APPLICATION FOR AMENDMENT TO PERMIT

Location 214 Park Ave 53-B-4 Within Fire Limits? _____ Dist. No. _____

Request for Variance under Sec. 14-440 - Exterior Egress

BUILDING PERMIT REPORT

ELEVATION
214 PARK
AVE.

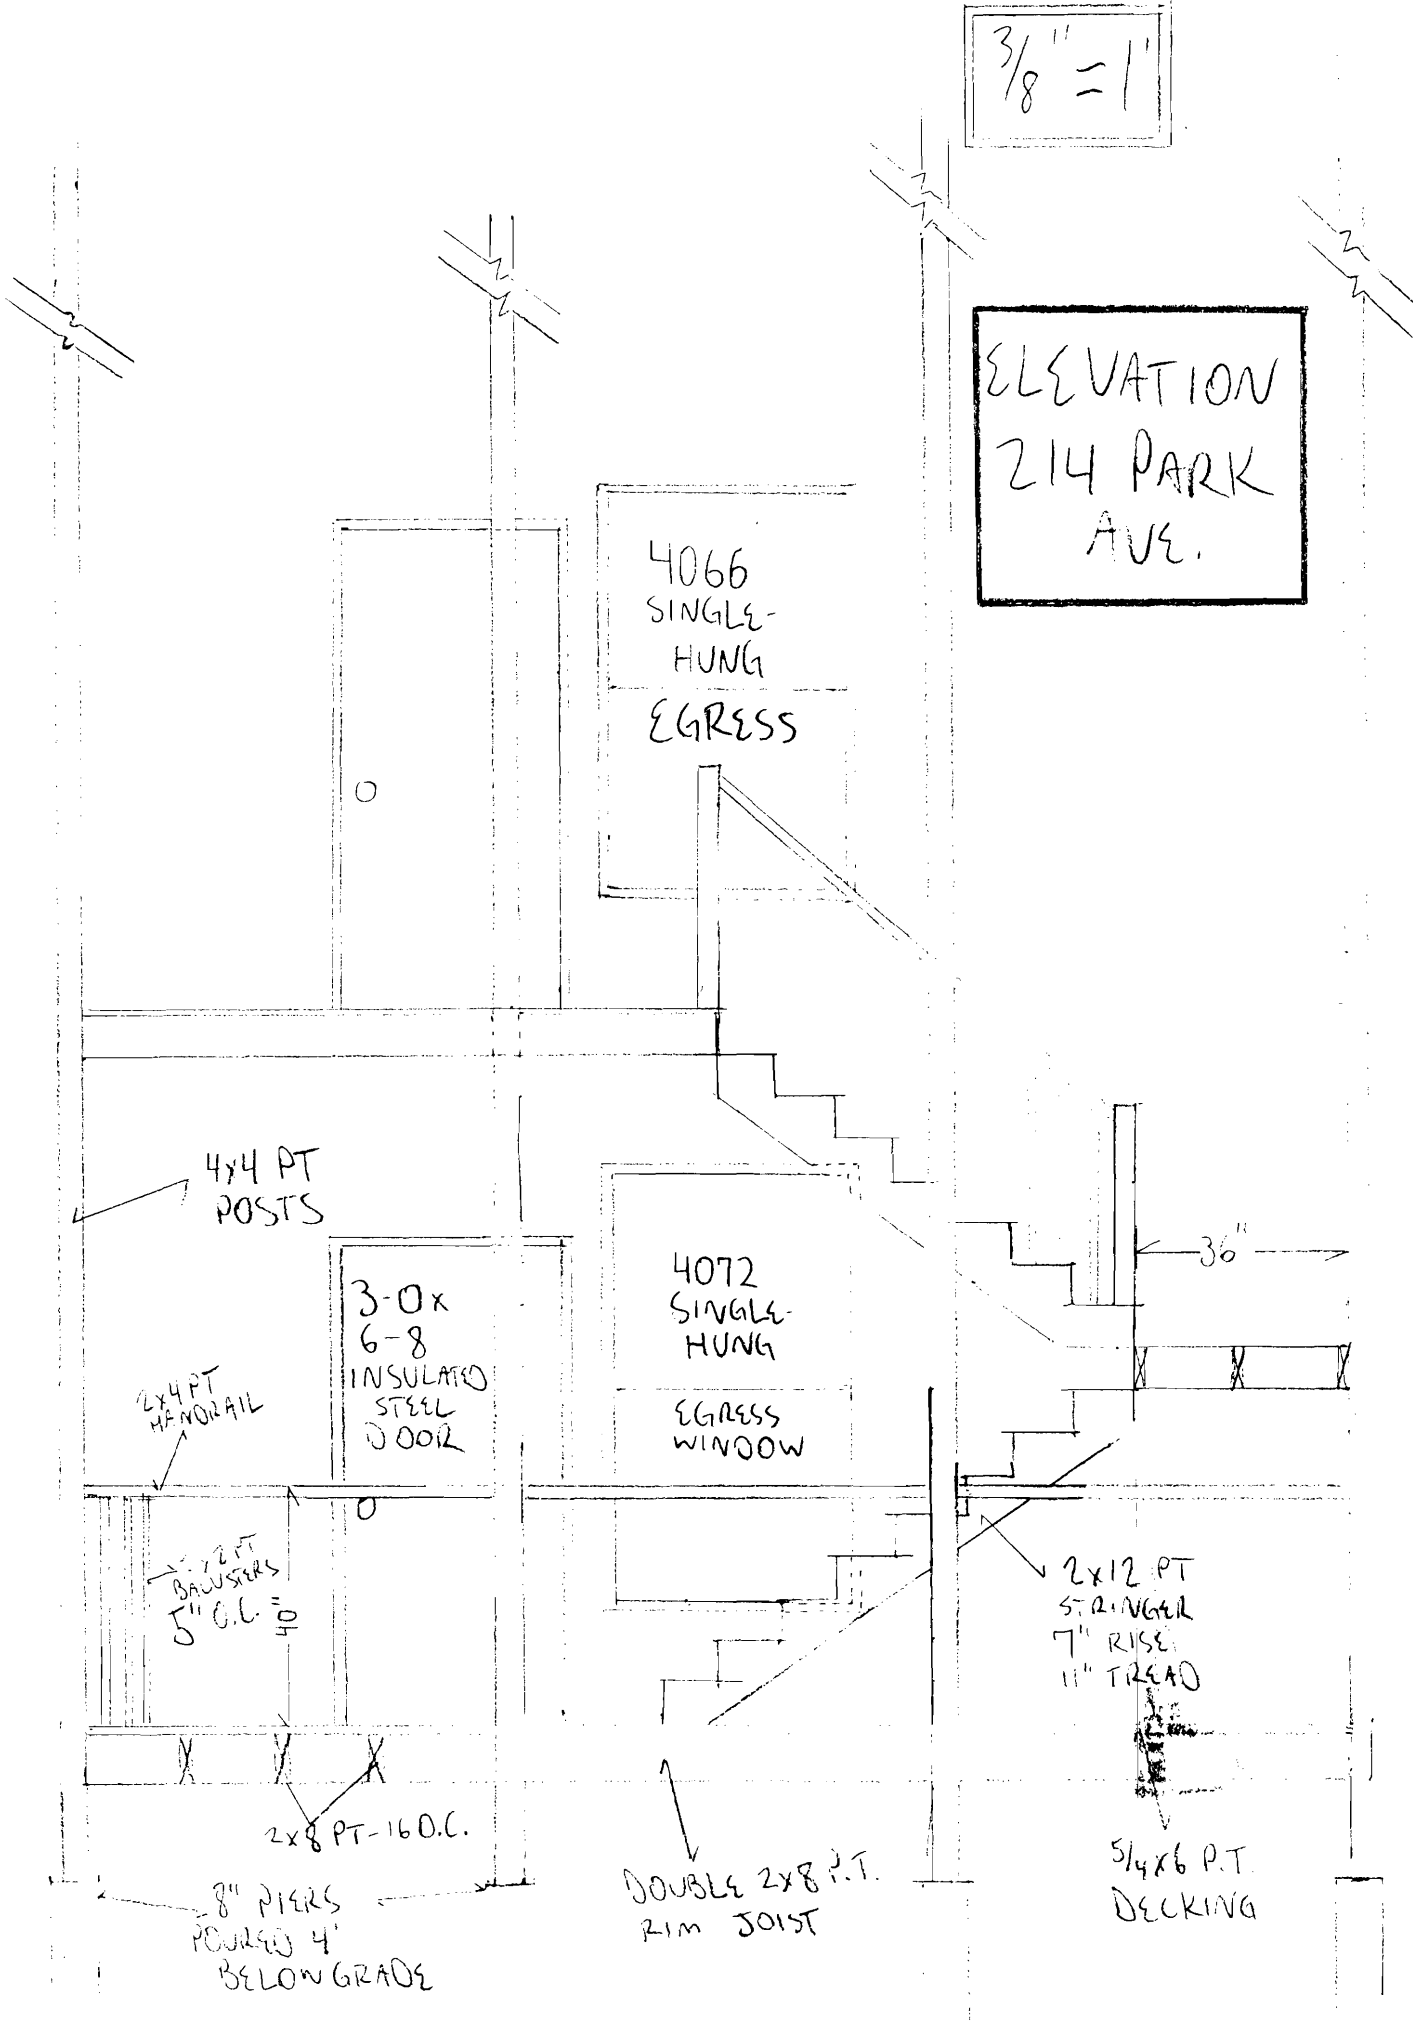
Approved with the following conditions: *1, *8, *29, *30, *31

8. Guardrails & Handrails: A guardrail system is a system of building components located near the open sides of elevated walking surfaces for the purpose of minimizing the possibility of an accidental fall from the walking surface to the lower level. Minimum height all Use Groups 42", except Use Group R which is 36". In occupancies in Use Group A, B, H-4, I-1, I-2 M and R and public garages and open parking structures, open guards shall have balusters or be of solid material such that a sphere with a diameter of 4" cannot pass through any opening. Guards shall not have an ornamental pattern that would provide a ladder effect. (Handrails shall be a minimum of 34" but not more than 38" Use Group R-3 shall not be less than 30", but not more than 38") Handrail grip size shall have a circular cross section with an outside diameter of at least 1 1/4" and not greater than 2"

29. All windows within 10' of fire escape must be protected.
30. Guards shall be 42" in height
- * 31. Chapter 10, Section 1014.2 Treads, plat forms and Landings which are part of exterior stairways in climates subject to snow or ice shall be protected to prevent accumulation of same.
